A303 Sparkford to Ilchester Dualling Scheme TR010036

8.8 Draft Statement of Common Ground with Defence Infrastructure Organisation

DRAFT STATEMENT OF COMMON GROUND

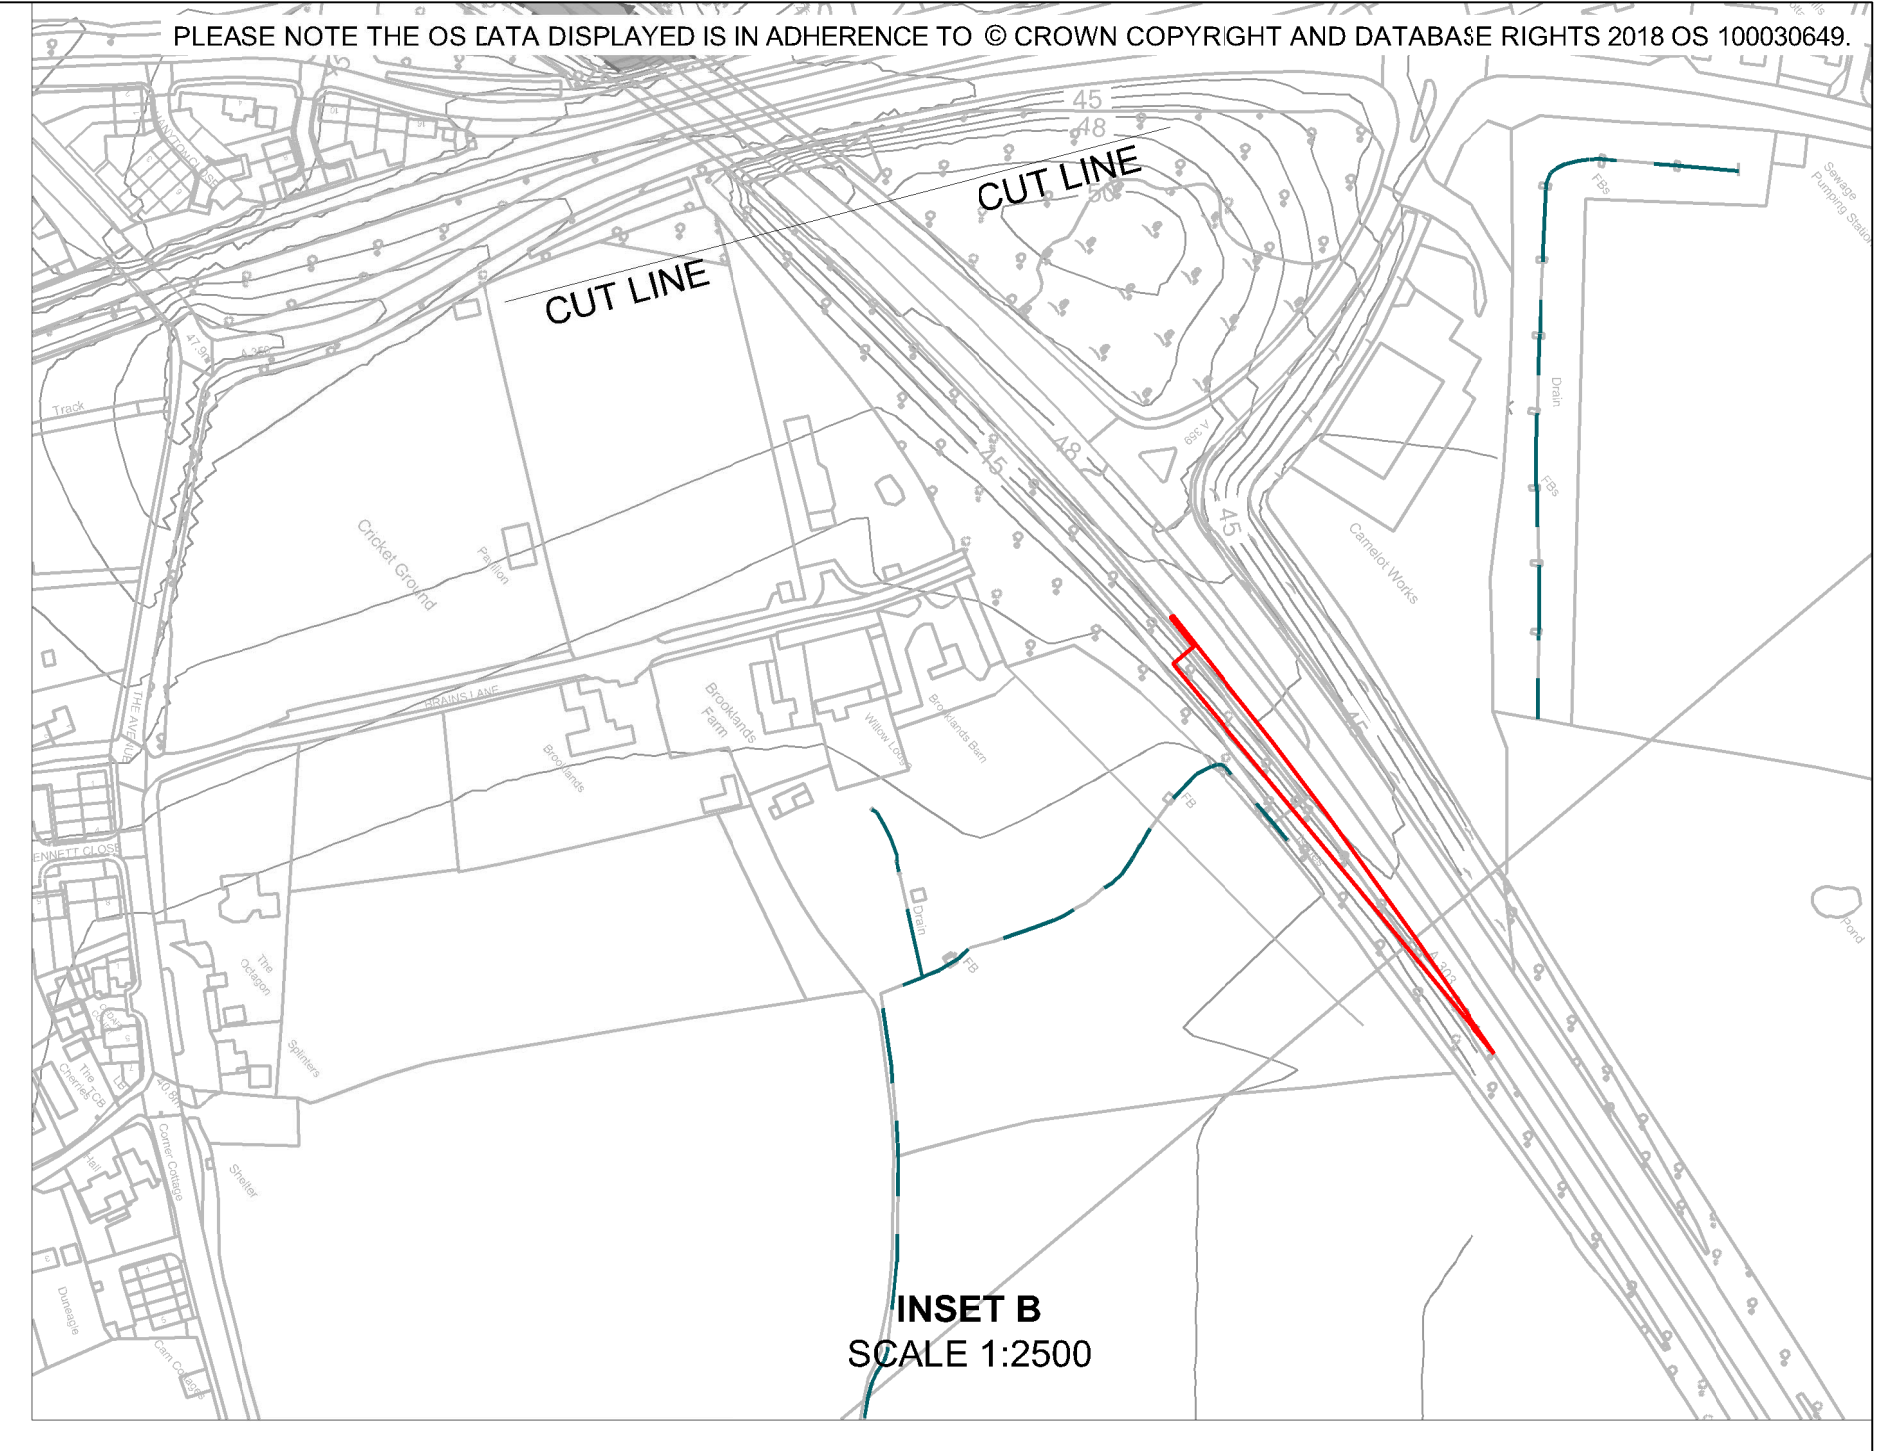
Topic	Sub-section	Defence Infrastructure comment	Highways England response	Status
General support to the scheme	General support for the scheme	The DIO supports the scheme and agrees for the need.	Acknowledged.	AGREED
Aerodrome safeguarding	Bird-strike safeguarding.	<p>The plan to build ponds to contain permanent standing water would attract birds and increase the risk for bird-strikes.</p> <p>The MOD statutory birdstrike safeguarding concerns remain extant. On meeting with HE we agreed if the ponds could not be dry i.e. only collect water during rainfall they should dry down within 72 hours following a 1 in 100 year storm event, there are alternative design principles such as densely planting the ponds with reeds in particular common reed Phragmites Australis as this provides a continuous year round barrier and does not die back in winter. The bank sides are to be as steep as possible and the reeds will need to be managed via a Bird Hazard Management Plan to ensure the reed is maintained to reduce the risk of attracting and supporting bird species deemed hazardous to aircraft safety in this area such as gulls, starlings etc. DIO understand at present detailed designs are not available and we would only be able to remove our concerns once formal pond designs are submitted for safeguarding analysis.</p>	<p>Highways England met with the MOD and DIO on 9 May 2019 to discuss the bird strike risk in relation to the proposed ponds. Highways England understands the concern raised by the DIO and believes there are a number of design options available to mitigate the risk to an acceptable level. Such options include designing the ponds to not hold water permanently; densely planting the ponds with reeds to deter birds; or designing the permanent body of water to be small so not to encourage birds – or a combination of these measures.</p> <p>In addition to the above, there will be no public access to these ponds to eliminate possible bird feeding.</p> <p>It is noted that the DIO consider the bird-strike risk still remains, however it was agreed during the meeting on 9 May 2019 that the above proposals are detailed design points and that the DIO will be consulted on the final design of the ponds during the detailed design.</p>	AGREED
